Great Yarmouth Third River Crossing Application for Development Consent Order

Document 6.7: EIA Scoping Opinion

SCOPING OPINION:

Proposed Great Yarmouth Third River Crossing

© Crown copyright
and database rights
2017. Ordnance
Survey 100019340

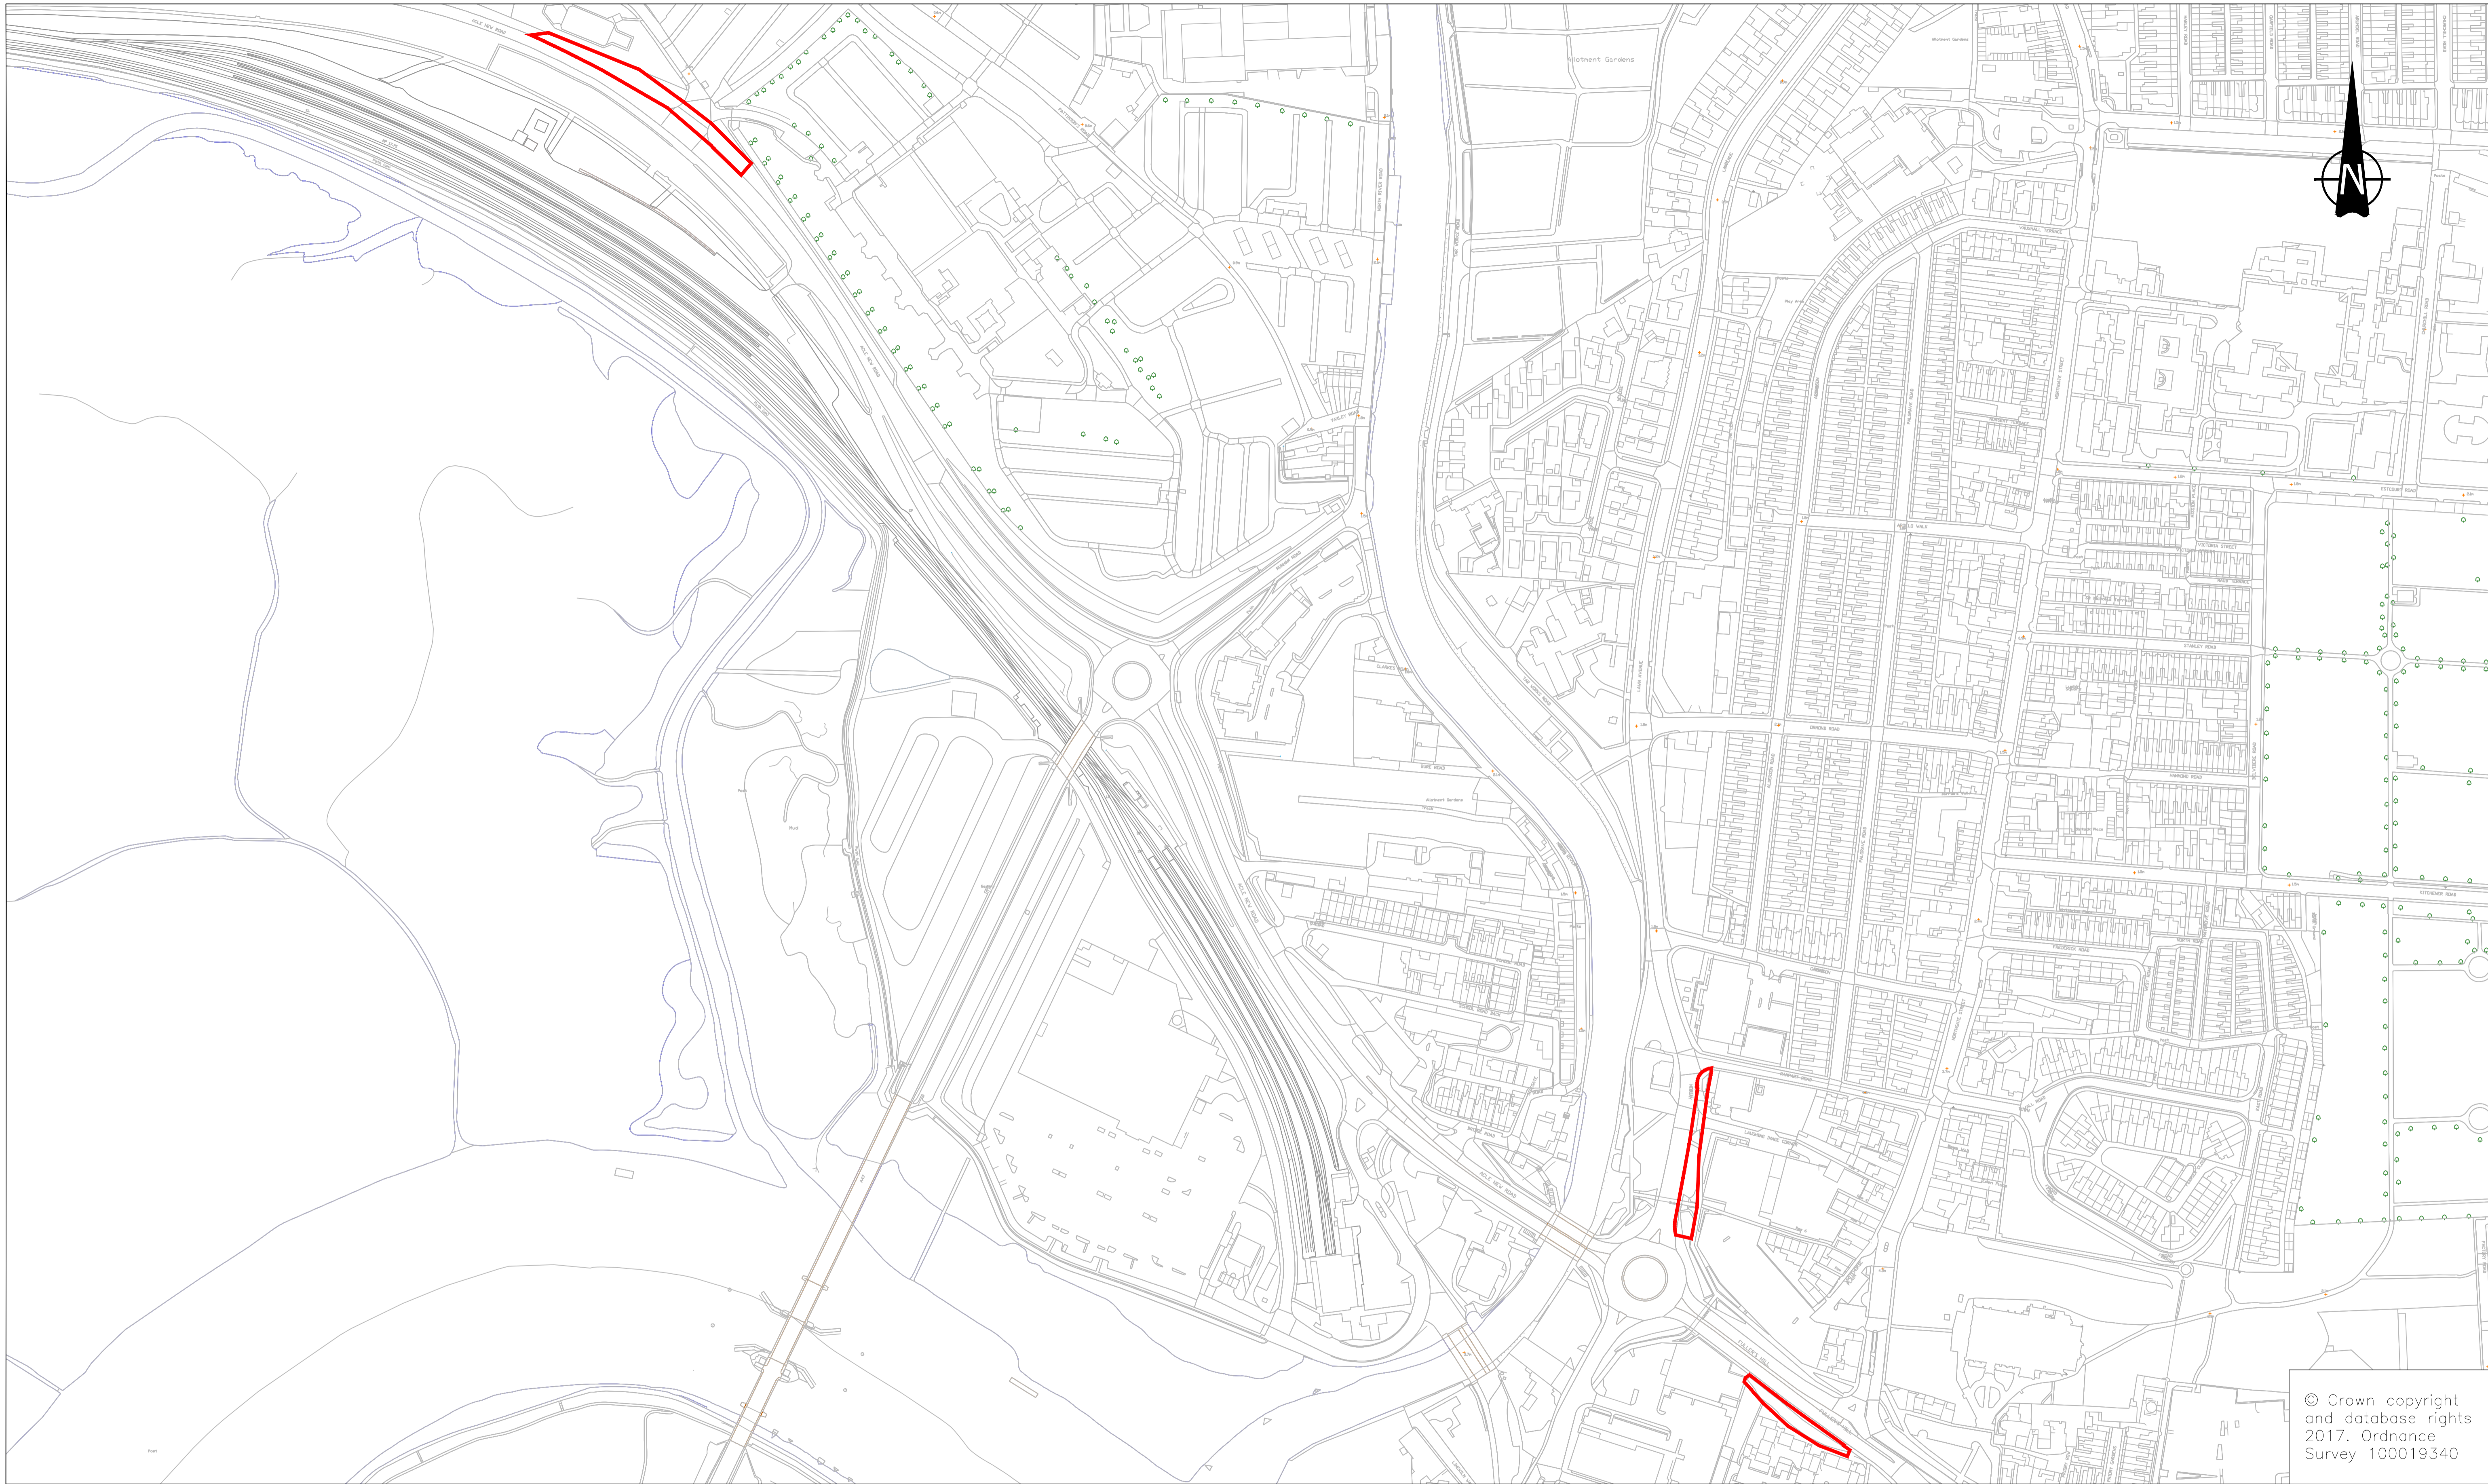
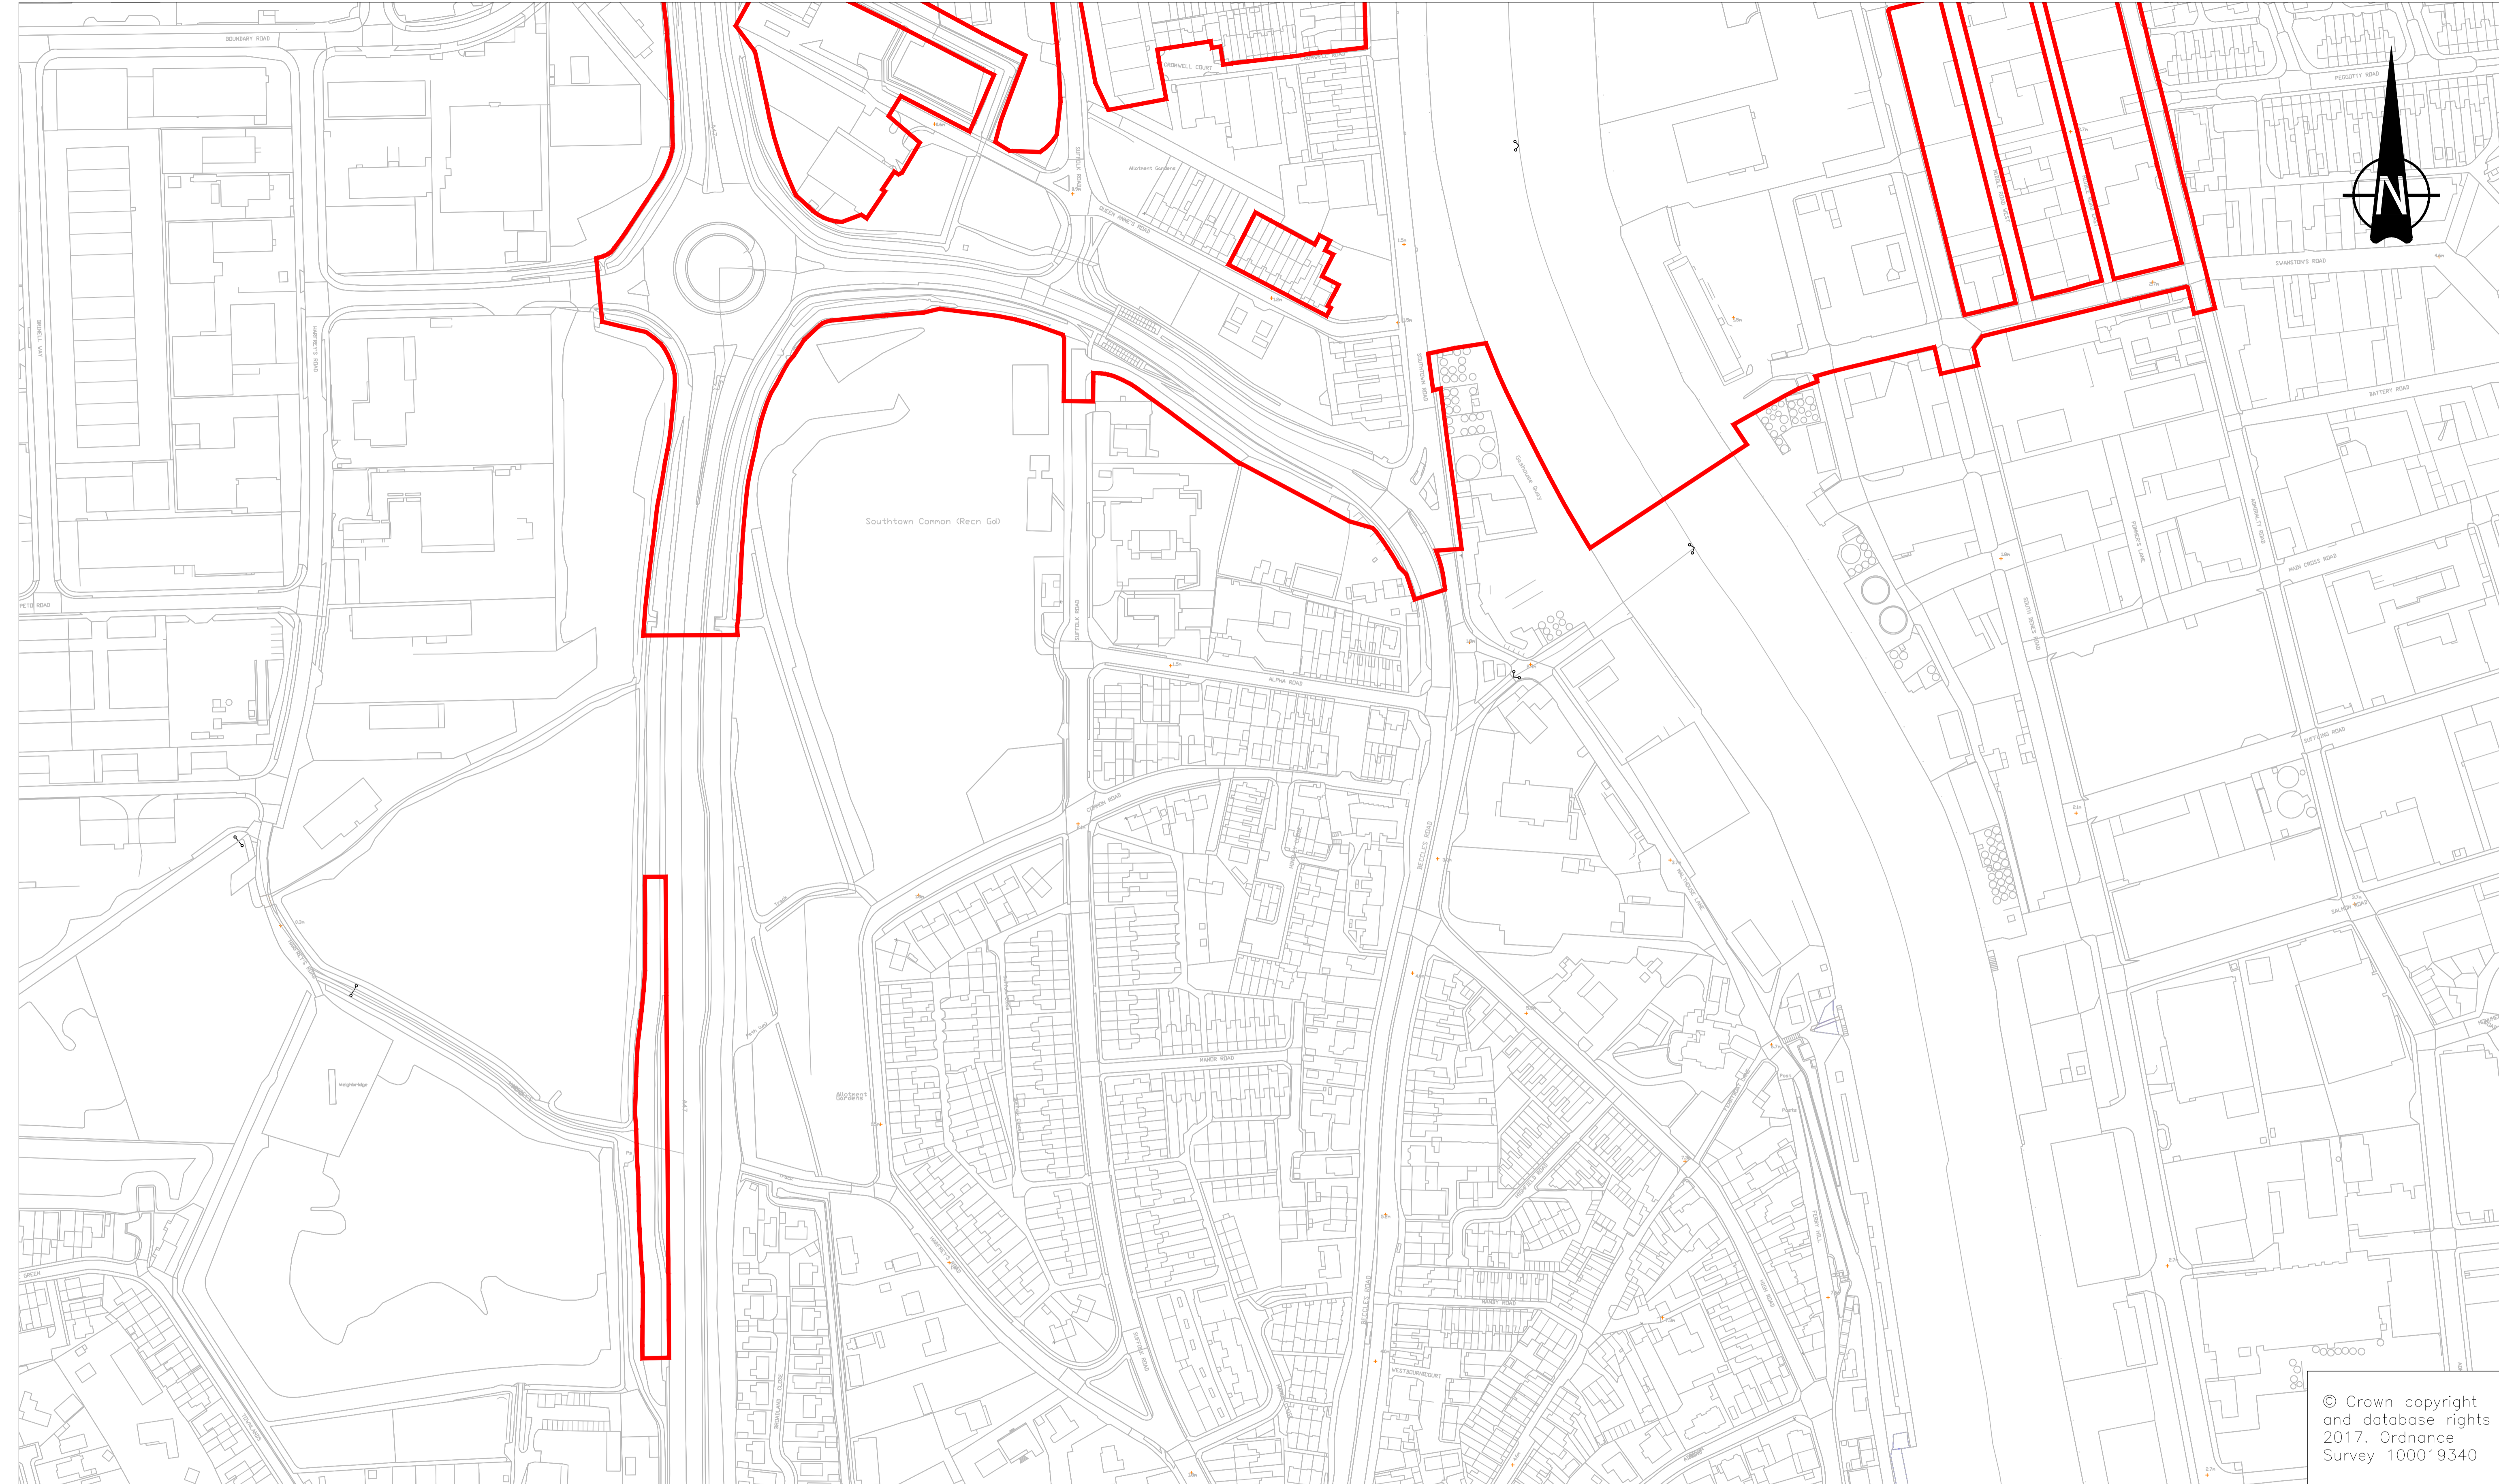
- 2.3.1 A description of the Proposed Development has been provided in Section 2 of the Scoping Report, supported by drawings and figures. The Inspectorate notes that the site boundary shown on Figures 2 to 5 in Appendix B is slightly different to the Scoping Report Boundary presented on drawing 62240375-GYTRC-Scoping Report Boundary-20180219. The Applicant should ensure the DCO application boundary for the Proposed Development is consistent on all drawings and figures that present this information in the ES, and ensure that the impact assessments have considered the full extent of the final DCO application.
